Harnett County Government Complex
307 W. Cornelius Harnett Boulevard
Lillington, NC 27546

April 14, 2023

Re: Providence Creek Pool and Pump/Bath house

This department has reviewed the plan you submitted for the Providence Creek swimming pool to be constructed at 196 Providence Creek Dr., Fuquay Varina. This plan review was conducted in accordance with the current North Carolina Rules Governing Public Swimming Pools (15A NCAC 18A .2500).

1 FLOOR PLAN
SCALE: 1/4" = 1'-0"

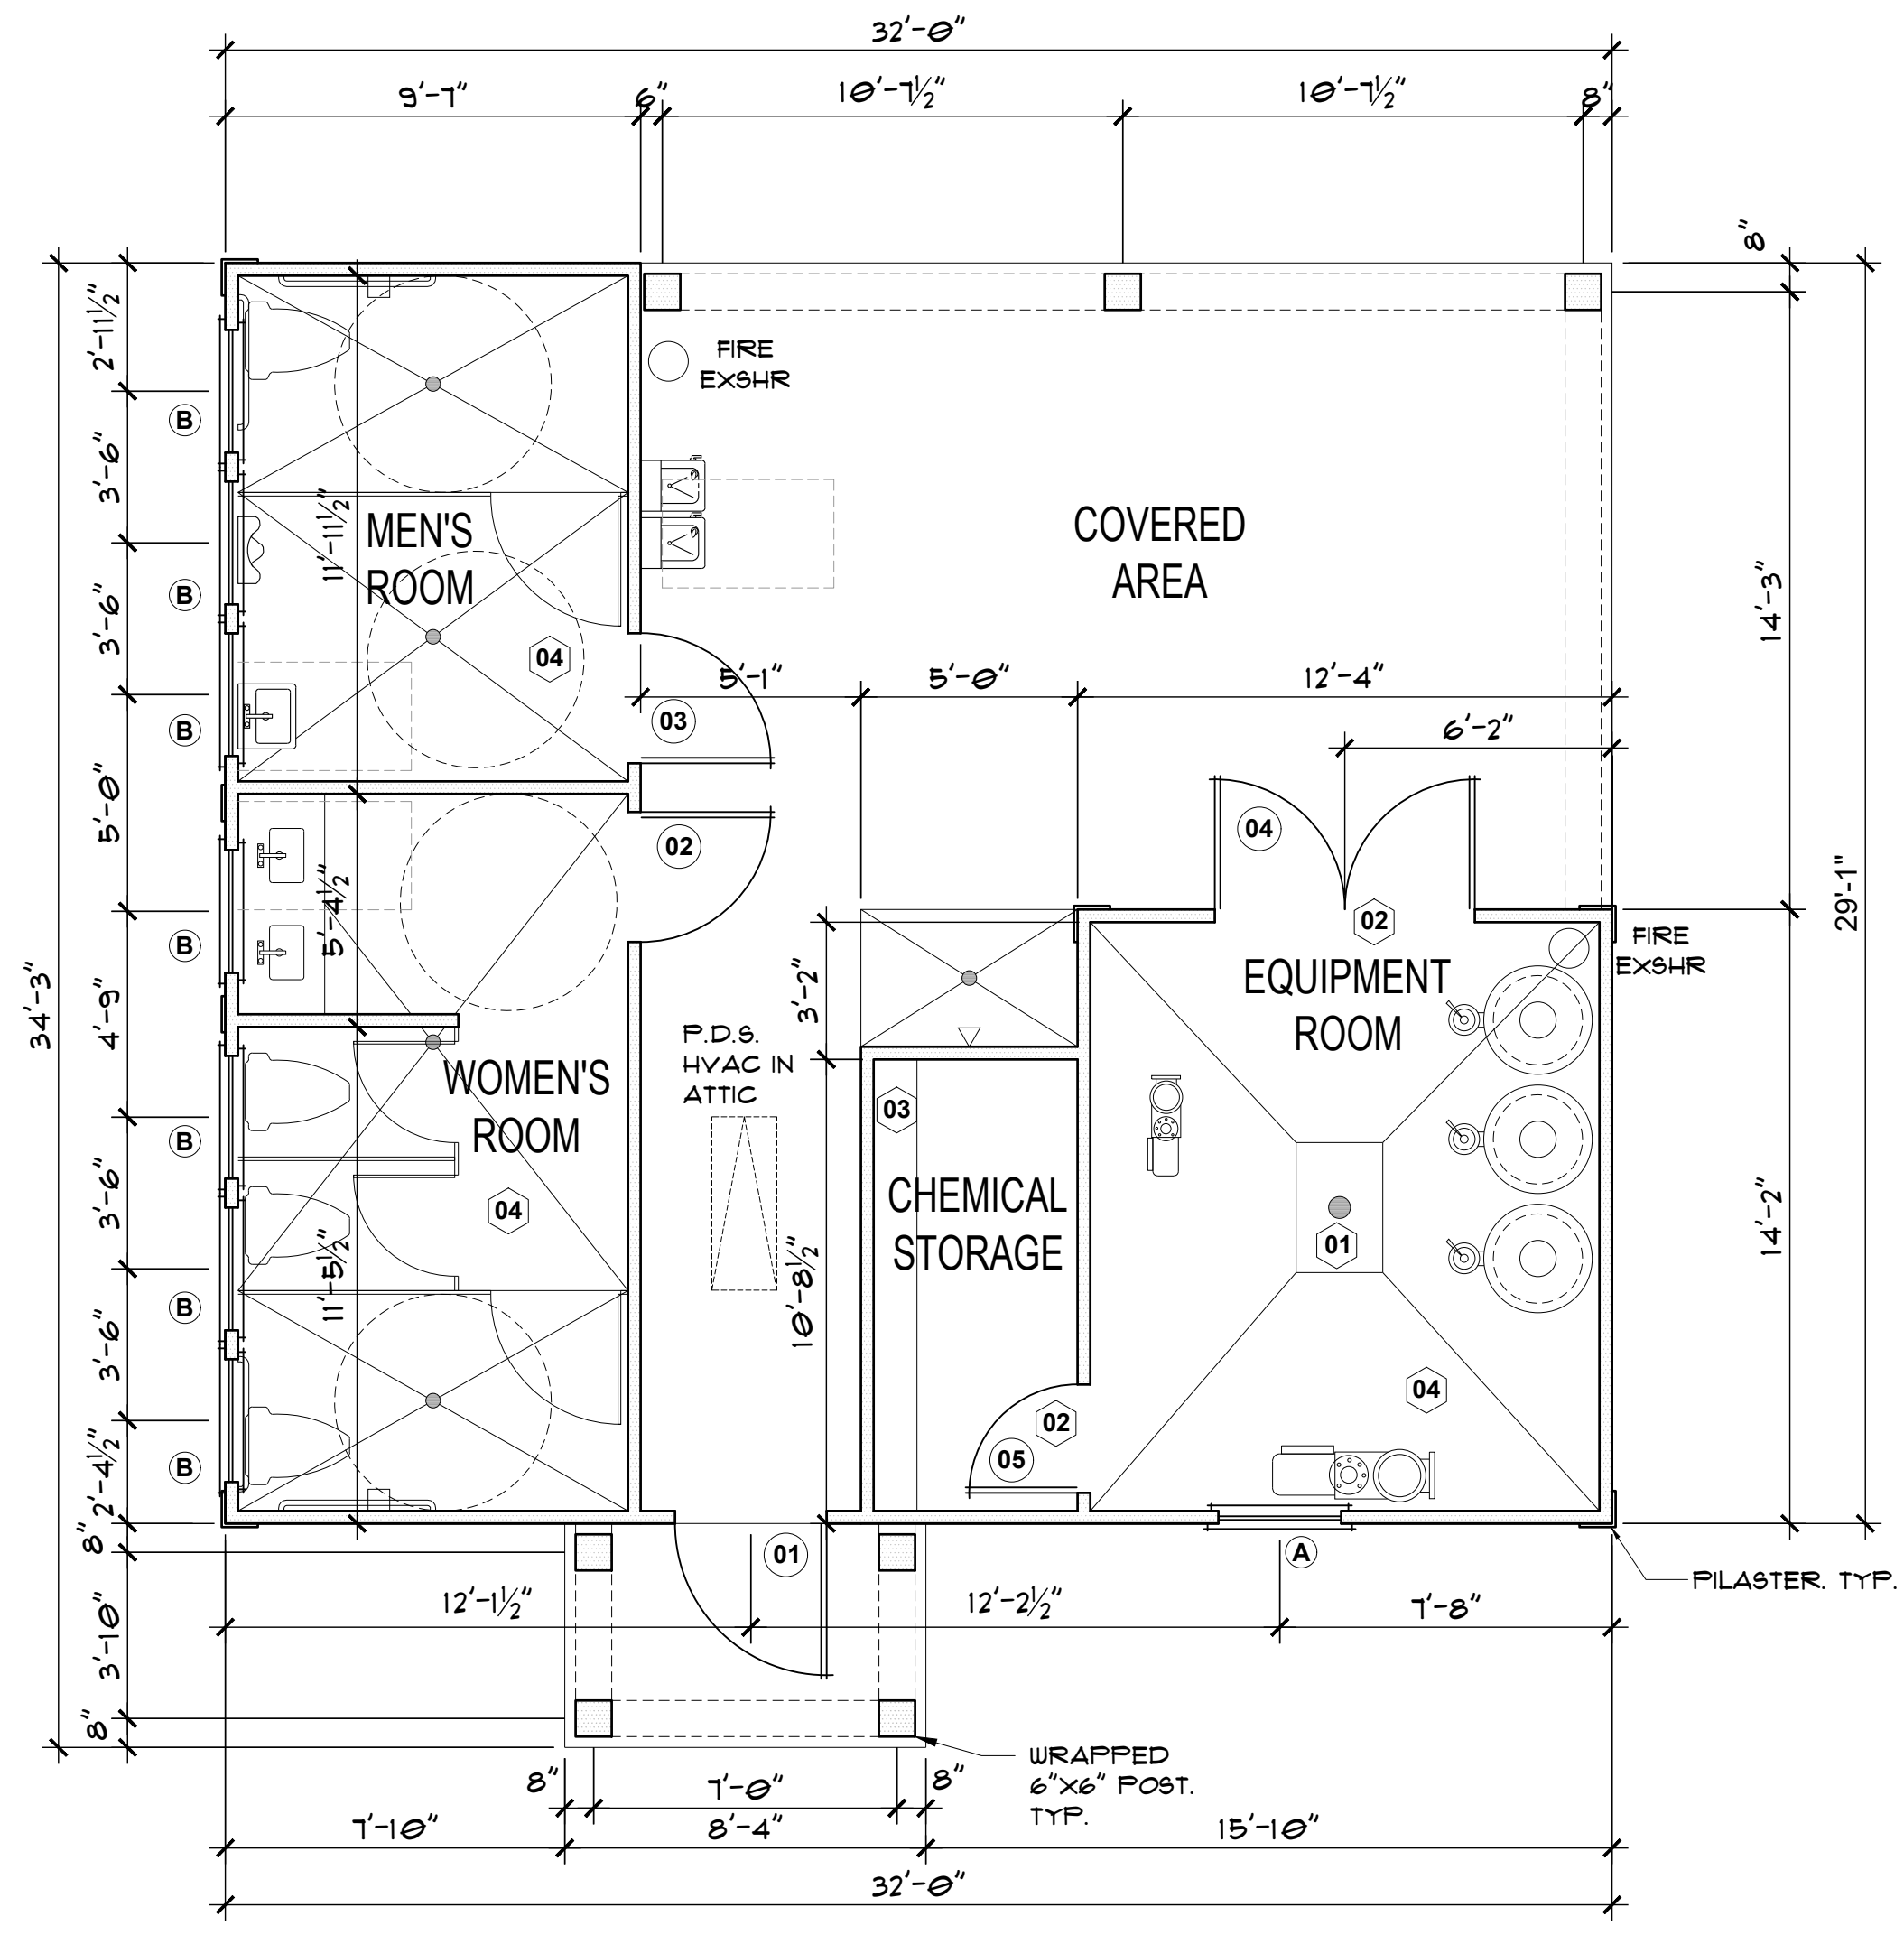
- Provide locations and specifications on all deck drains
- Specify pool finish color
- Indicate exact location of Emergency phone installation
- Provide a make/model or specification for a hydrostatic relief valve assembly
- Provide updated make/model information regarding SOFAs to be installed on both the main drains and the water feature
- Verify that neither pump to be installed will be variable speed
- Provide greater detail on backwash sump pit. Plans indicate pit to be 2" depth.
- Indicate whether mirrors in restrooms are shatterproof
- Provide additional information concerning partitions in restrooms, specifically, materials of construction and whether a waterway is provided under partitions
- Indicate if the ceramic floor tile in the restrooms is slip resistant
- Provide updated fencing data if available
